**CITY OF ALBUQUERQUE
PLANNING DEPARTMENT
January 9, 2013
DRB Comments**

PROJECT # 1009544

CITY OF ALBUQUERQUE
 ADMINISTRATIVE APPROVAL (AA)- SITE DEV PLAN AMENDMENT
 ROUTING & REVIEW SHEET

**RE: SITE PLAN FOR BUILDING PERMIT, ADMINISTRATIVE AMENDMENT
PROJECT NUMBER 1009544, DRB NUMBER 13DRB-70458
OLD DOMINION FREIGHT LINE, 330 AIRPORT RD NE
ZONE ATLAS PAGE K-10**

Sheet Name:  
**GRADING AND  
 DRAINAGE PLAN**  
 Sheet Number:  
**C2**

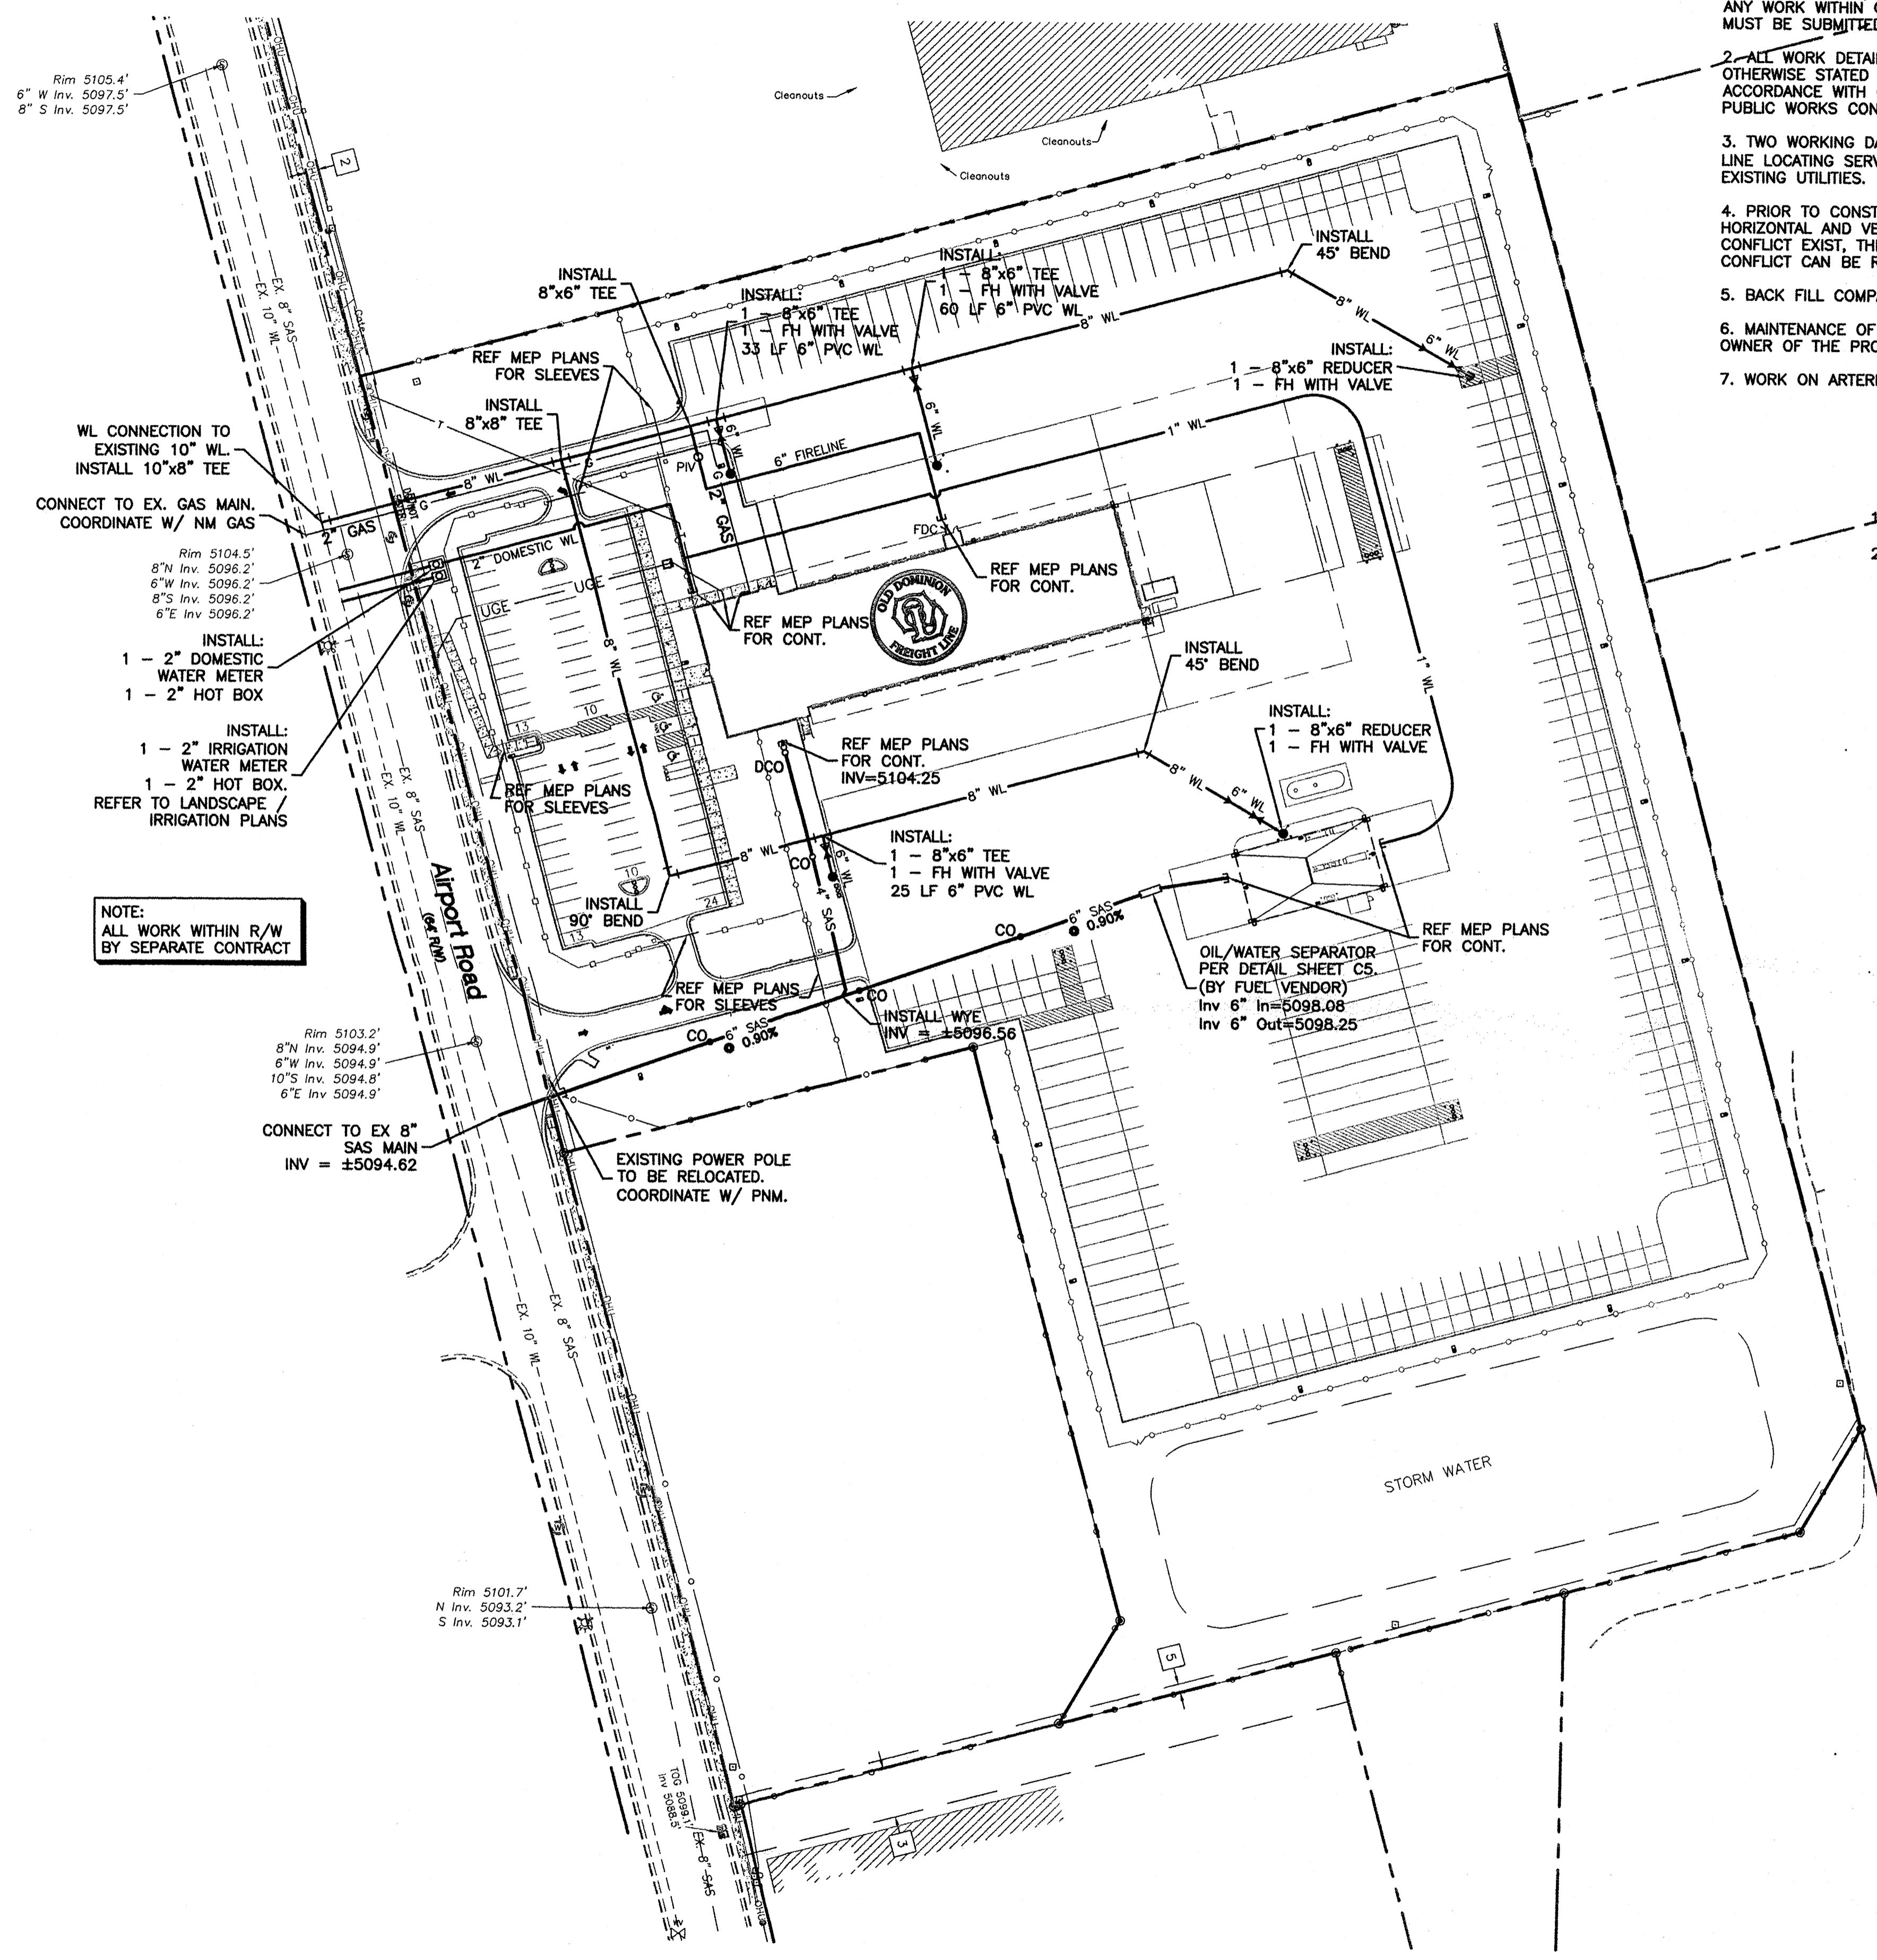
HYDROLOGY (505) 924-3986	DATE RECEIVED: <i>10-16-13</i>
PLANS DISAPPROVED: <i>Amber Chen</i>	DATE: 10-16-13
PLANS APPROVED: <i>Amber Chen</i>	DATE: 10-16-13
COMMENTS: The approved grad showed inlets and SD from the south curb line, which will not be build w/ this AA. <i>cc 10-16-13</i> Submit a revised grading and drainage plan that shows how the site will drain to the park. Engineer contribution was submitted on 10-16-13.

Sheet Name:
SITE PLAN FOR BUILDING PERMIT

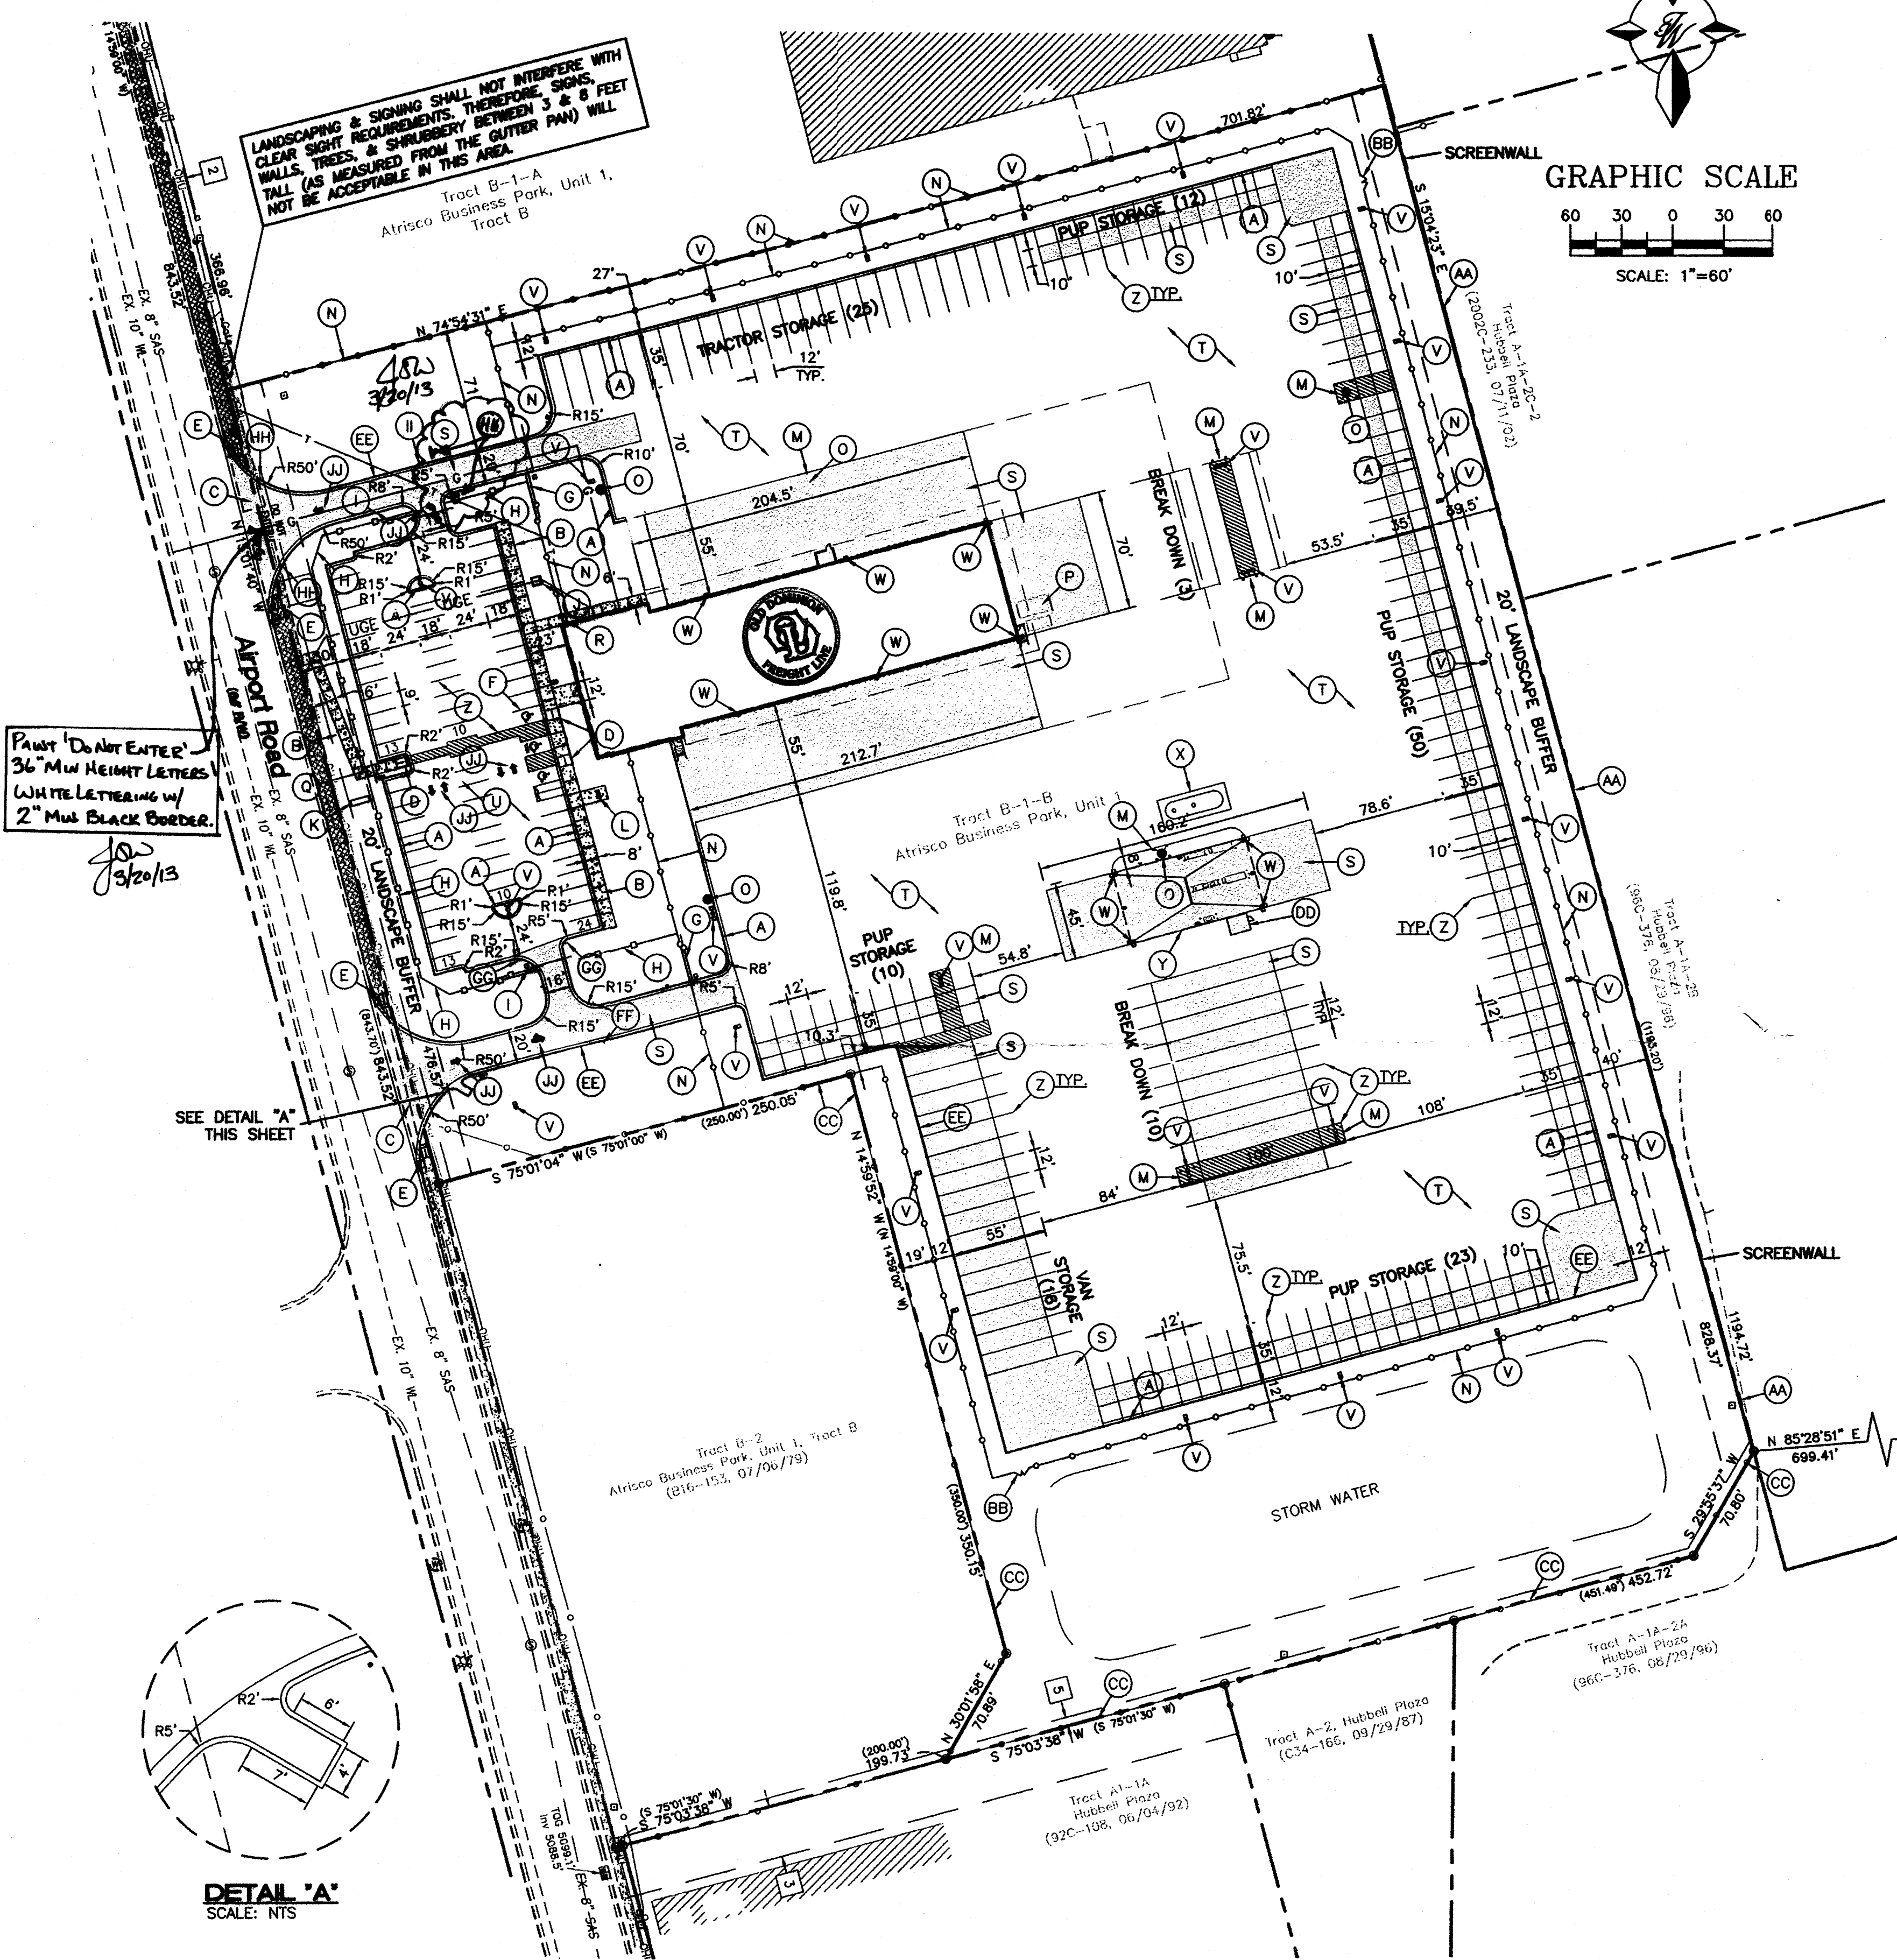
As discussed on 9/13/13, the current approved site plan shows a total of 149 total storage spaces for trailers. After the site plan was approved, Old Dominion decided that they currently need a reduced number of trailer storage spaces and will expand the parking lot for trailer storage at a later date when needed. The attached amended Site Plan reflects the reduction in the parking lot for trailer storage. This area is labeled as Phase 2. We have also shown a new concrete curb that was installed as the boundary between Phase 1 and Phase 2.
